**From:** Elliott, Stanice  
**Sent:** Tuesday, January 10, 2017 11:41 AM  
**To:** 'David Soule'  
**Subject:** 6405 Picardia

Based upon the information provided in your submittal received 12-12-2016, the above referenced plan cannot be approved for PERM CO until the following comments are addressed:

ENGINEER'S SEAL	6405 PICARDIA NUCE RESIDENCE	DRAWN BY WCWJ
	GRADING AND DRAINAGE PLAN	DATE 5-19-16
		21616-LAYOUT-5-18-16
5/18/16	1606 CENTRAL AVENUE SE SUITE 201 ALBUQUERQUE, NM 87106 (505) 872-0999	SHEET #
DAVID SOULE P.E. #14522		JOB # 21616

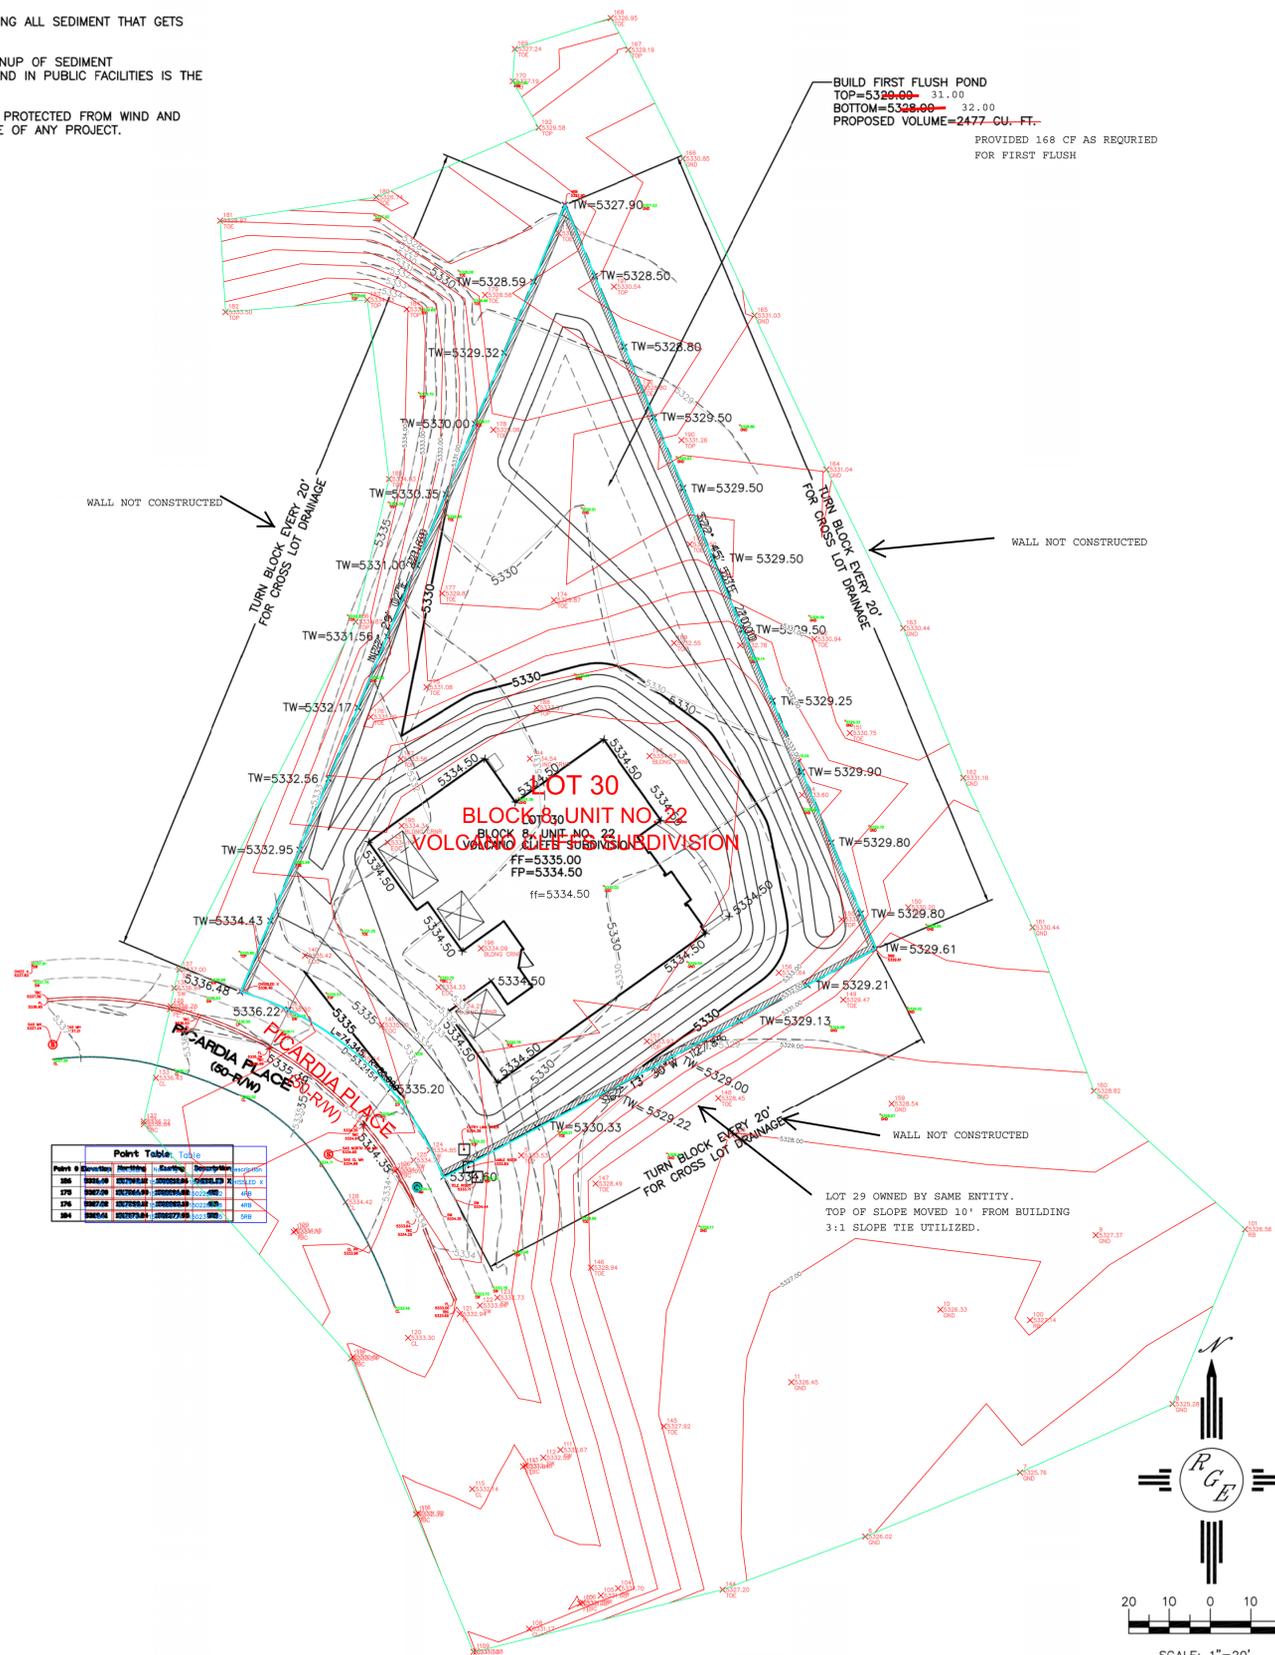
- The grades on site do not match grades on the approved grading and drainage plan
- Provide as-built grades
- Ensure that the grades match the approved SAD 228 Master Drainage Plan.
